**RE: Lot 11 Block 4 Unit 22 SAD 228  
6409 Canavio Rd. NW  
Volcano Cliffs Subdivision  
Grading and Drainage Plan  
Engineers Stamp Date 1/25/2022 (D10D003D11)  
Pad Certification Date: 3/24/2022**

Based upon the information provided in your submittal received 3/28/2022, this plan cannot be approved for Building Permit until the following comments are addressed..

G1

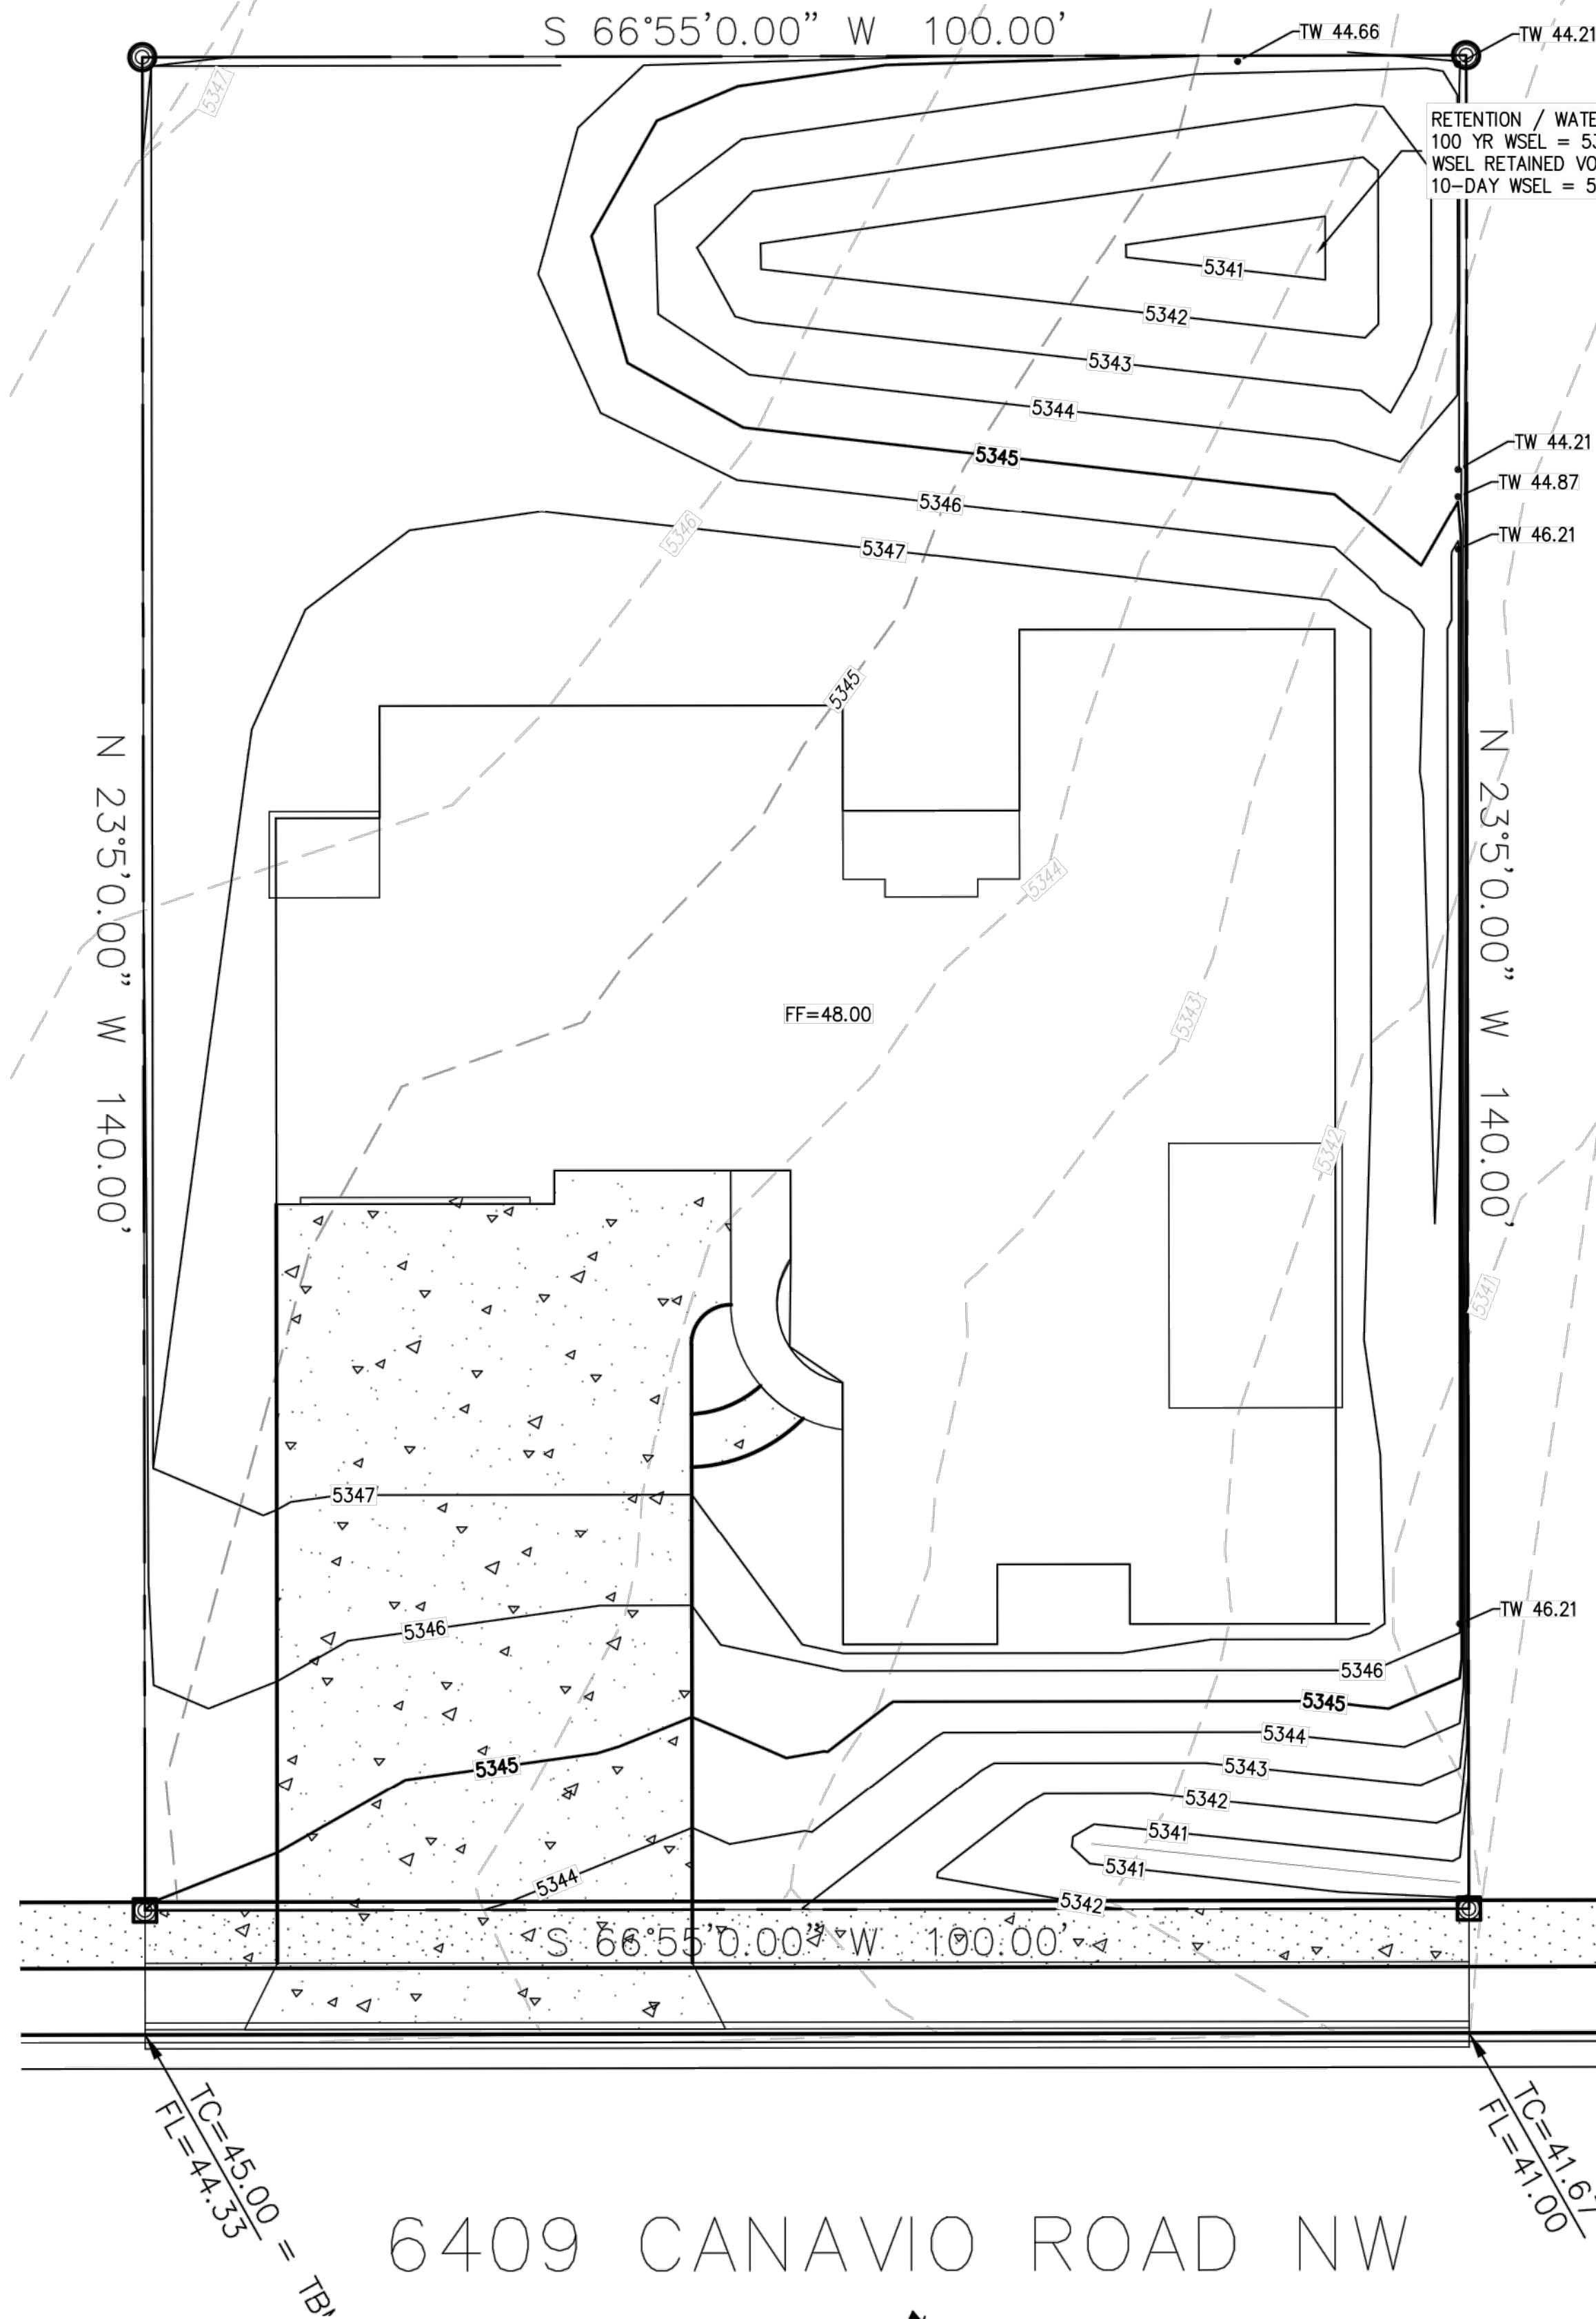
Due to the height restrictions in SAD 228, the finished pad cannot be higher than 1 foot above the curb height, unless there are extenuating circumstances which are called out on the plans in the notes section. Please revise the FP for this building.
